From: Neeltje Chappell [REDACTED]
Sent: 27 April 2022 12:21
To: Hannah Kersley <Hannah.Kersley@arun.gov.uk>
Subject: RE: Planning Consultation on: BN/35/22/DOC

I'm emailing regarding your application for the discharge of conditions for Shelley House (BN/35/22/DOC). Please see below the email from the Drainage Engineer regarding comments on the Surface Water Drainage. She has requested for some further information and has asked that you provide:

Application No: BN/35/22/DOC

Site Address: Shelley House Church Lane Eastergate PO20 3UR

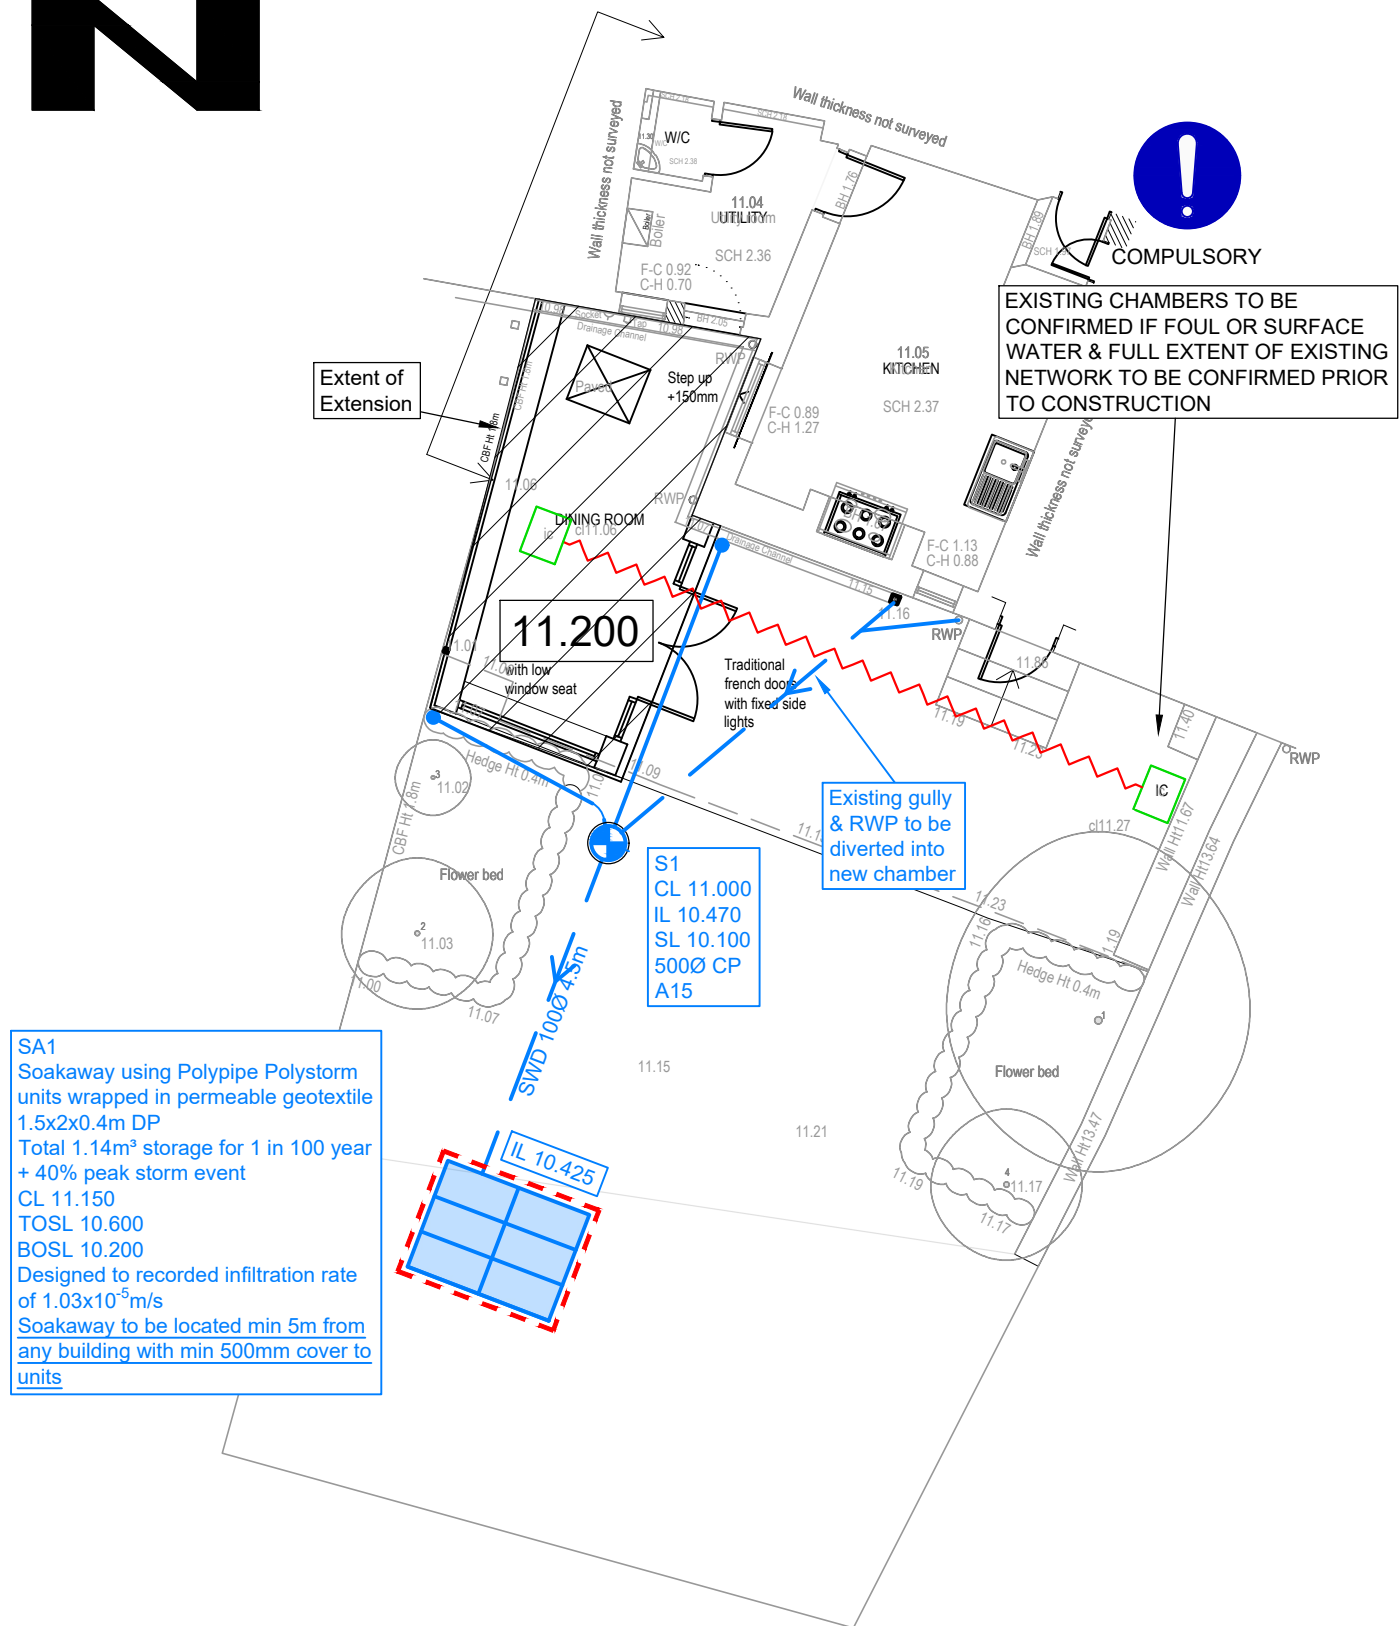
1. An impermeable area plan showing what areas from the existing roof and from the proposed extension will be drained to the new soakaway.
2. Please can the invert level of the incoming pipe to the soakaway be shown on the drainage layout. At present it could easily be misunderstood to be laid at the base of the soakaway.

Please find attached a copy of the updated drainage report showing the Invert level of the incoming pipe on the drainage layout. I have also attached an impermeable area plan as requested.
